Morris Goding
Access Consulting

18 February 2021

RE: Sirius Redevelopment - Response to Department of Planning, Industry and Environment Accessibility Statement Final

3 DDA TYPE 3H - 18.19.01 - PRE

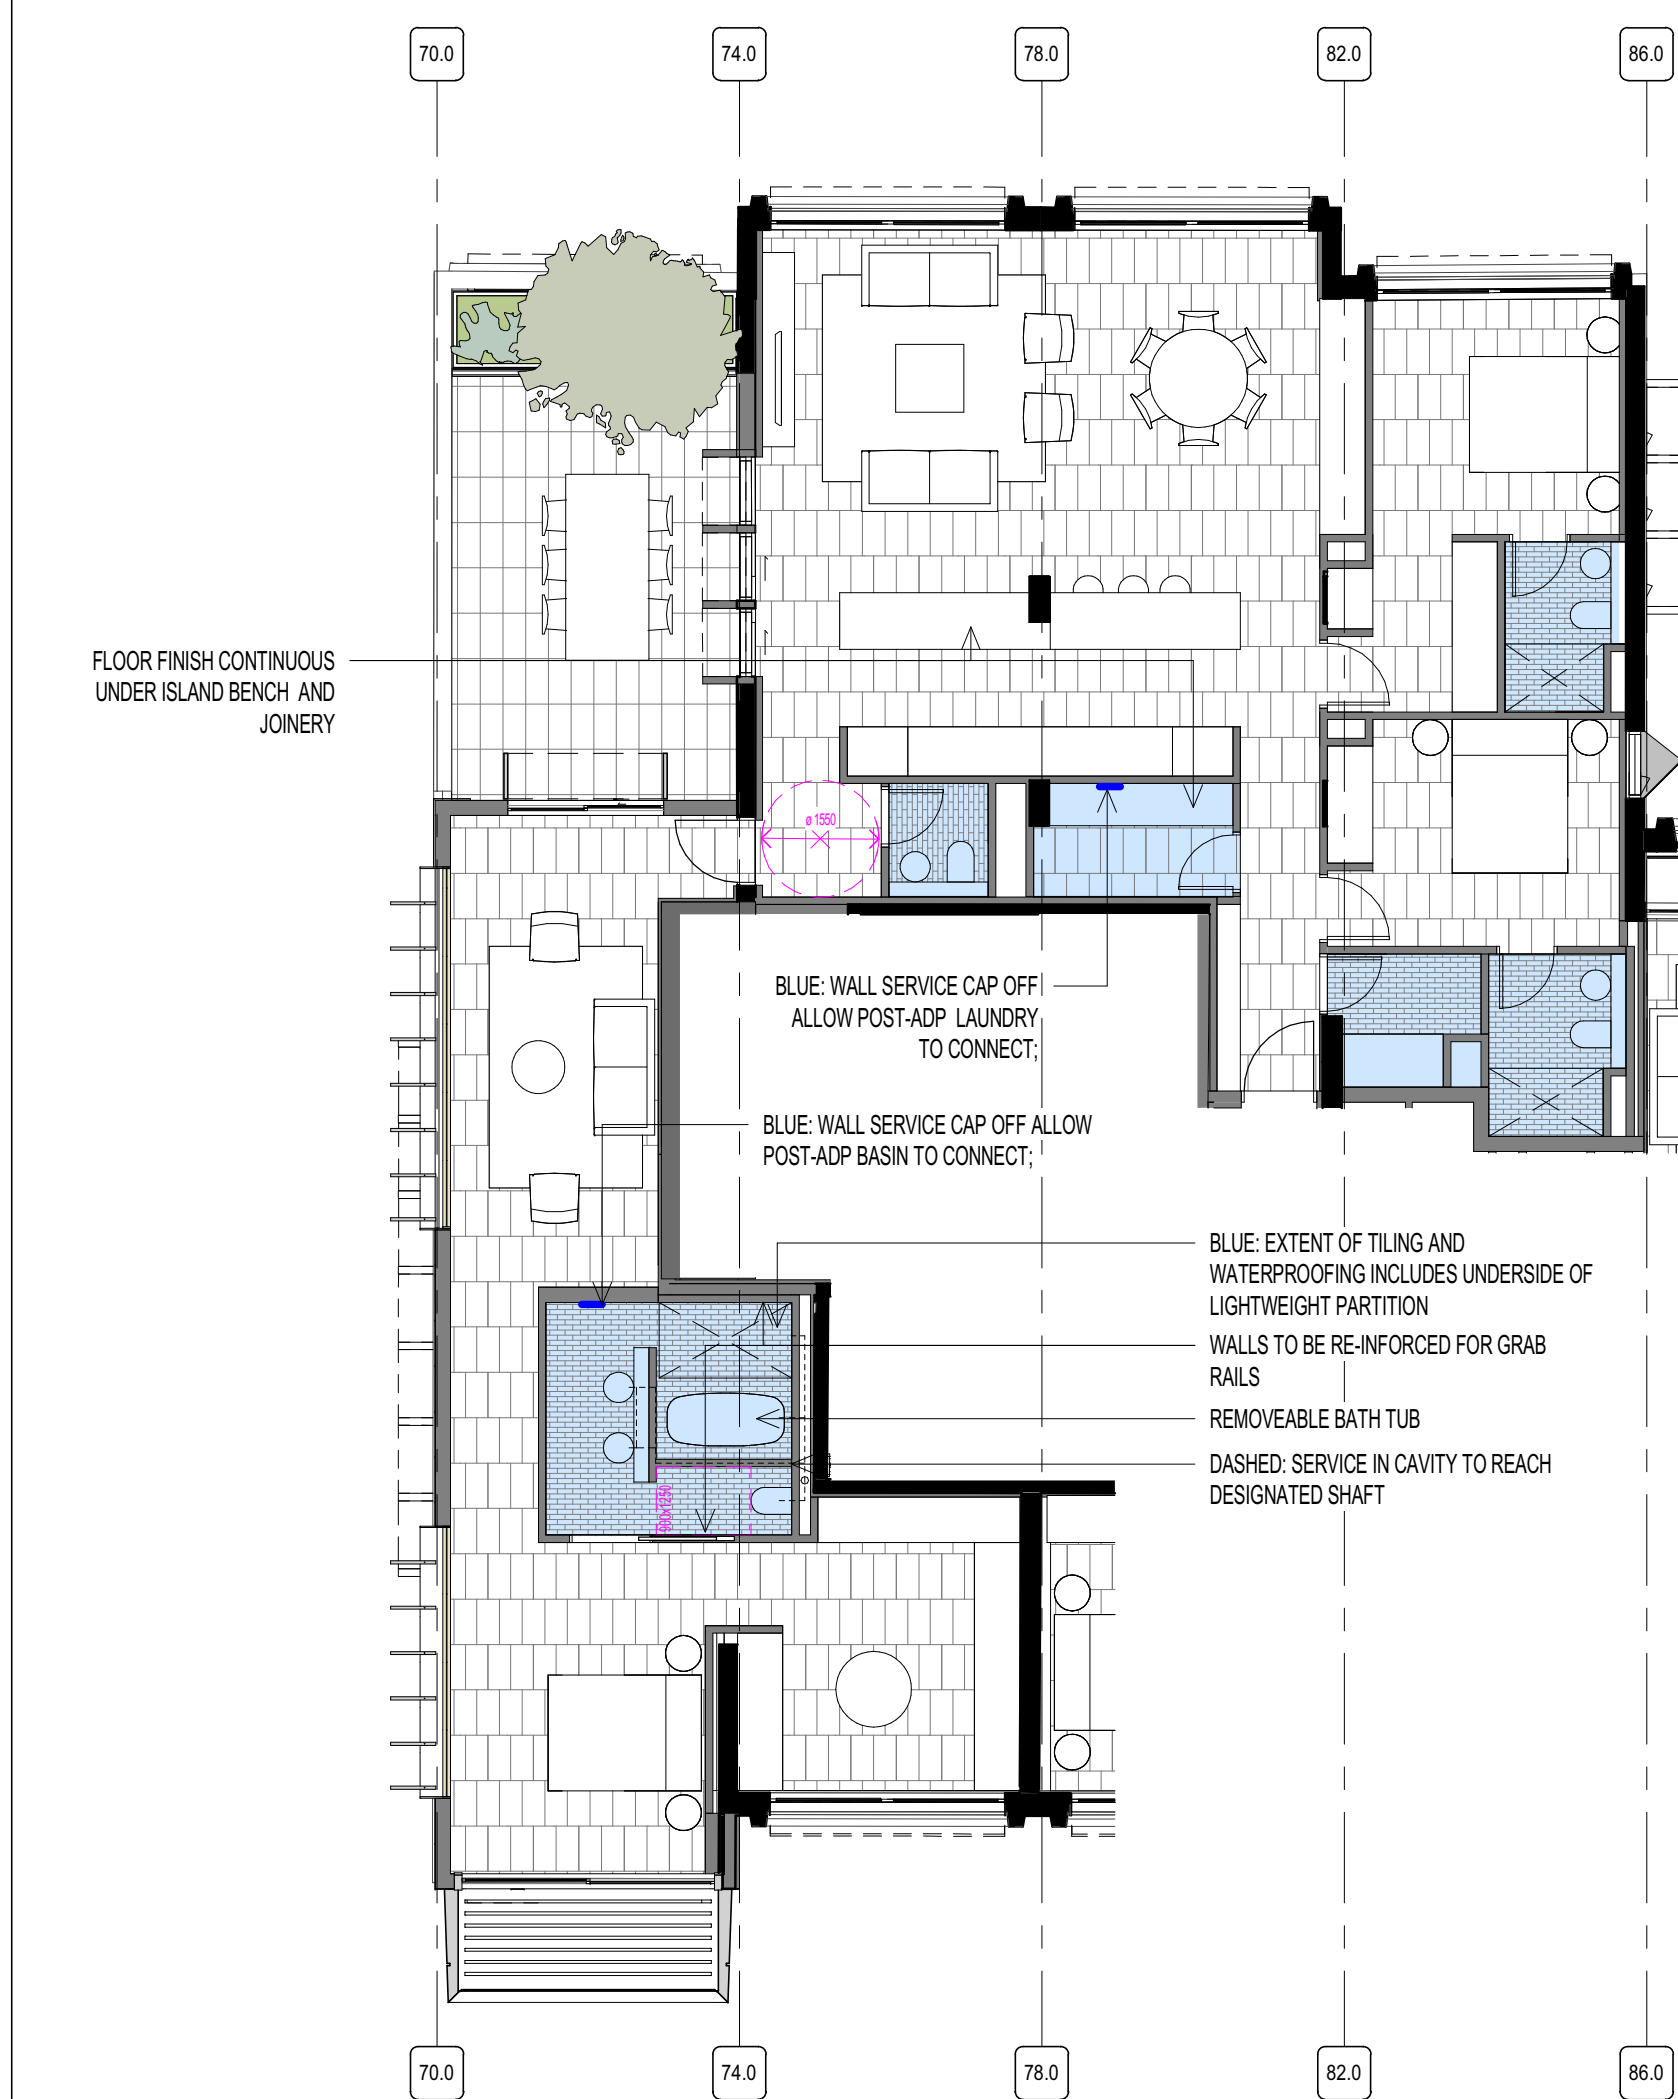
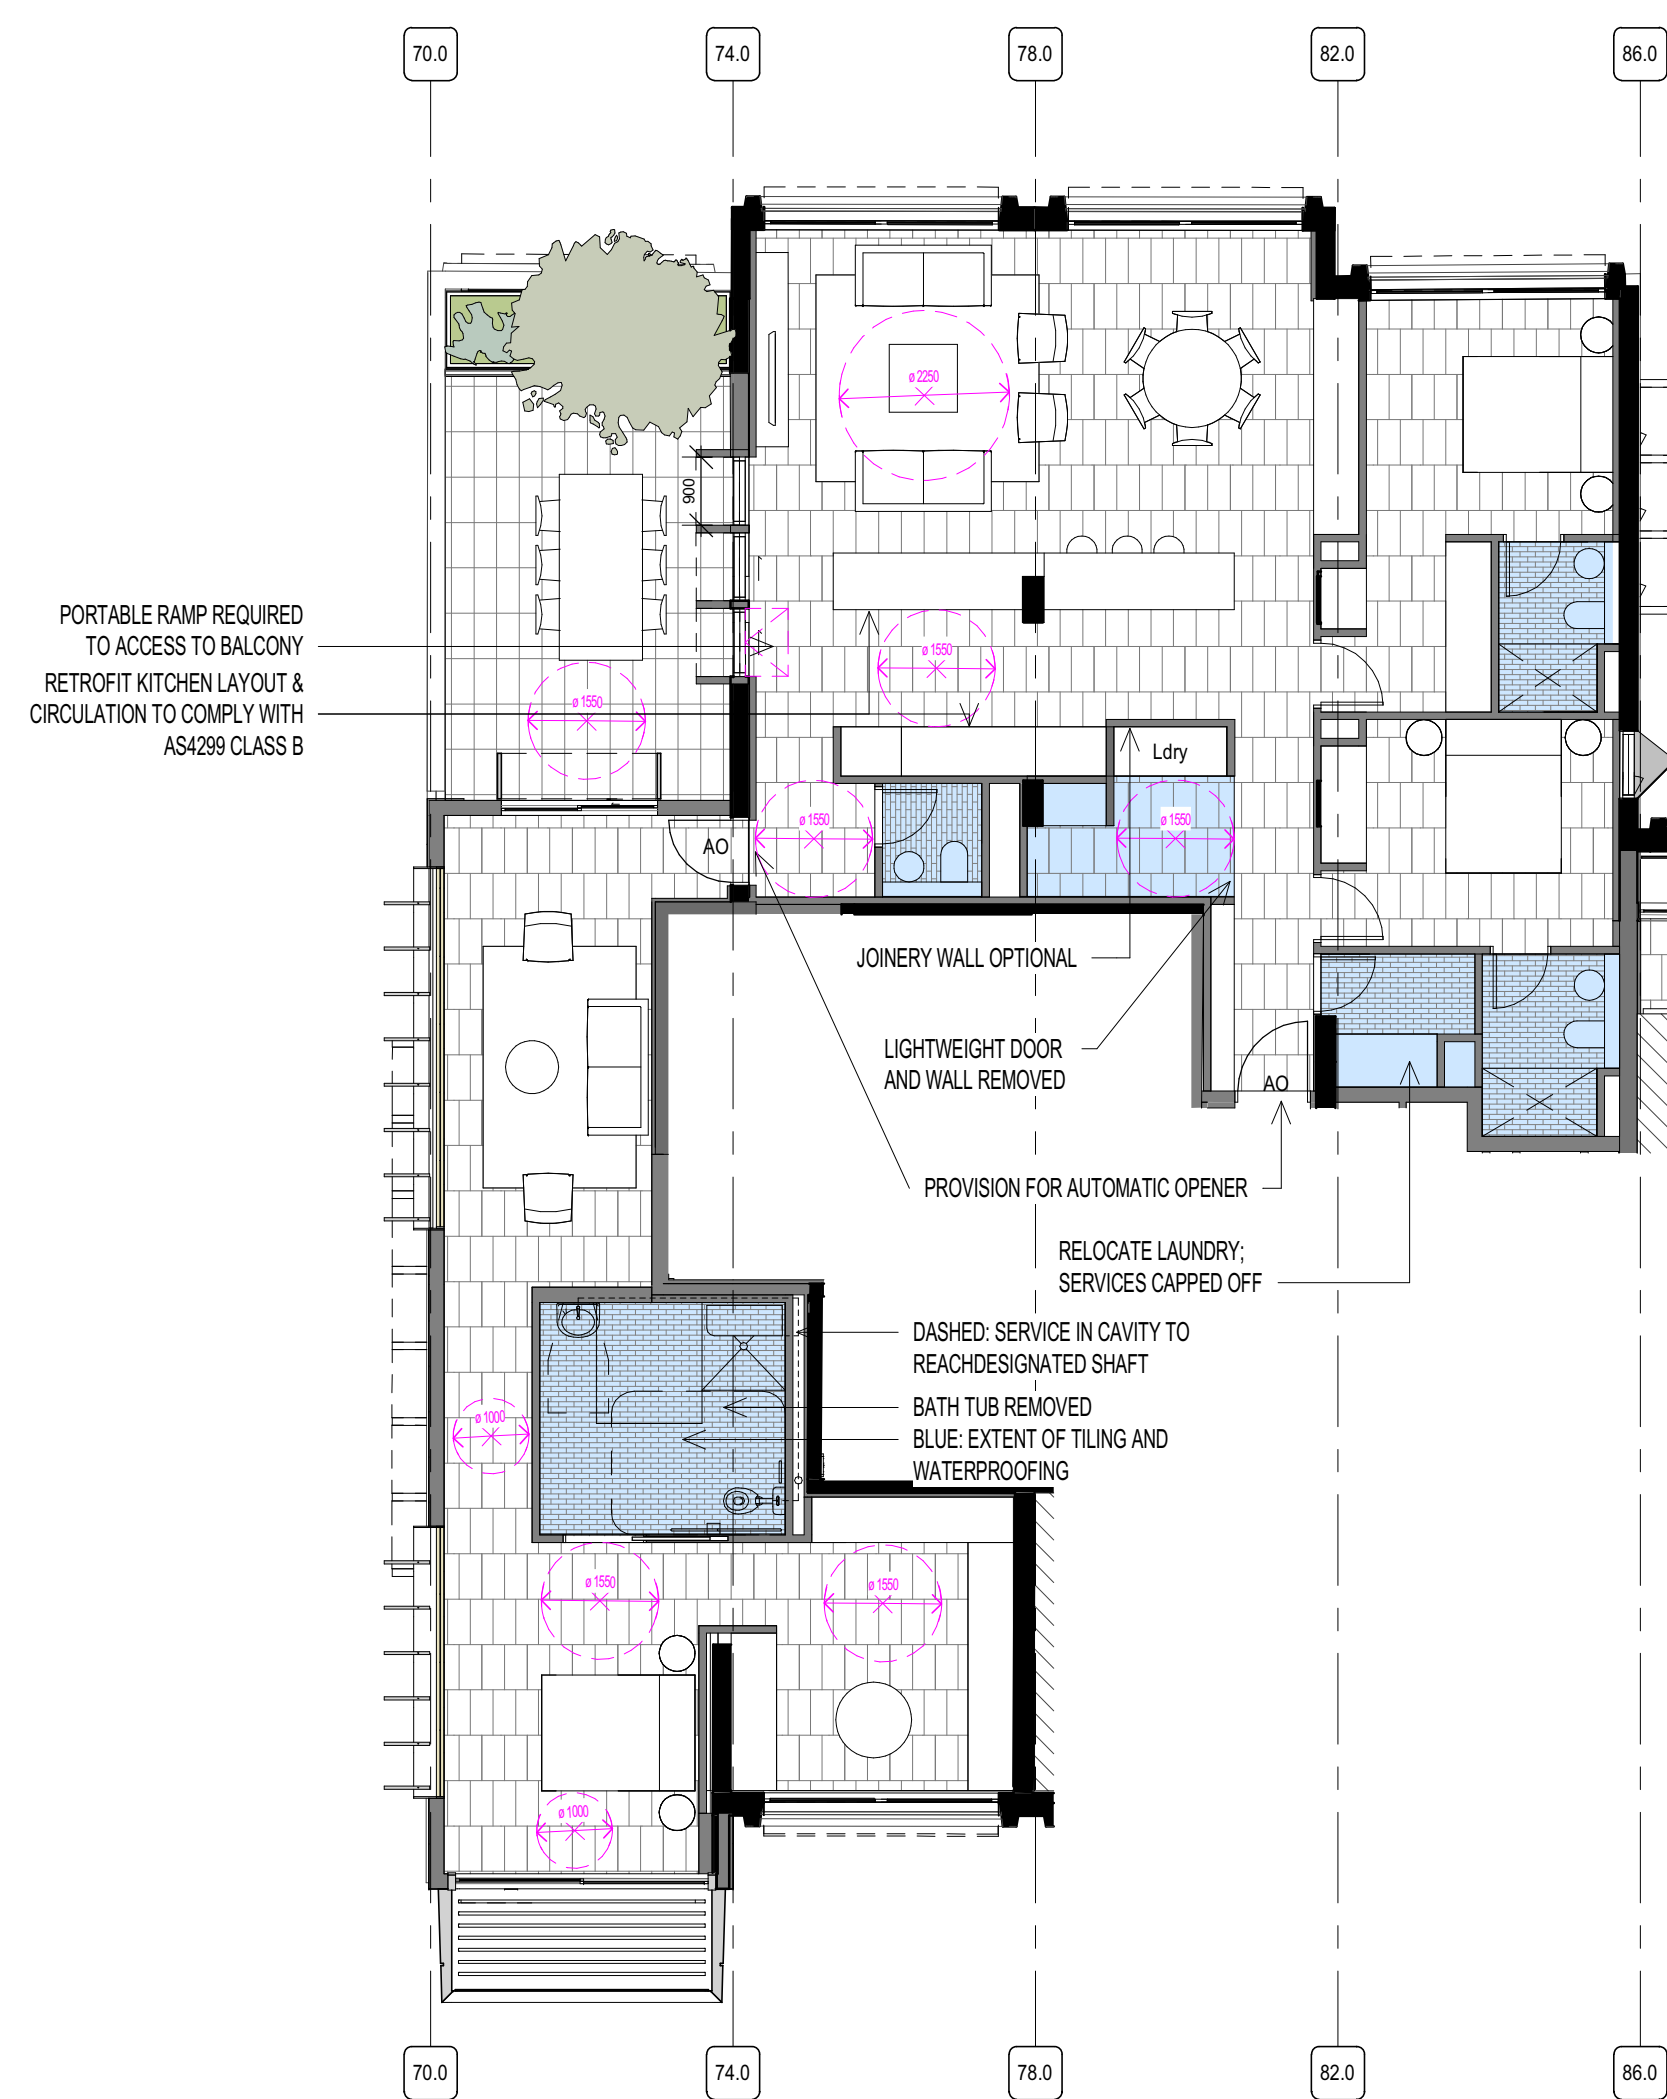
The design of adaptable unit types 3F and 3H (attached in Appendix A below) were assessed within MGAC’s Access Impact Statement and feedback from the City of Sydney Council is

- The accessible bathrooms to adaptable unit types 3F and 3H will show toilet pans and shower recess falls retaining their position between pre and post adaptation and capped off services for the where the washbasin will be relocated at post adaptation are included from the outset. The walls within the bathrooms are annotated lightweight partitions for easy removal at post adaptation. Waterproofing includes the underside of these lightweight partitions. Wall strengthening will be provided from the outset in the toilet pan and shower recess walls to allow for easy future installation of grabrails as per AS4299. As per the provisions of AS4299, a removeable bathtub is permissible.

- The kitchen island benches in adaptable unit types 3F and 3H may be relocated at post adaptation as stipulated in AS4299. The post adaptation drawings show a potential configuration that will comply with AS4299 Clause 4.5. The drawings show continuous flooring underneath the island kitchen bench and the sink waste will be located at the back of the bench such that upon adaptation, the existing joinery can be shifted back to achieve the required circulation spaces. It is MGAC's opinion that the provision of continuous flooring underneath the island bench and suitable location of the sink waste will ensure that adaptation will minimise inconvenience and cost.

- The comments relations to the changes required in the laundry for both adaptable unit types 3F and 3H are noted. Drawings show capped off services in the future location of the laundry provided from the outset and initial joinery can be easily removed as continuous tiling has been provided in this location.

noted. The design has been adjusted to reduce the cost and effort required to during post adaptation stage.
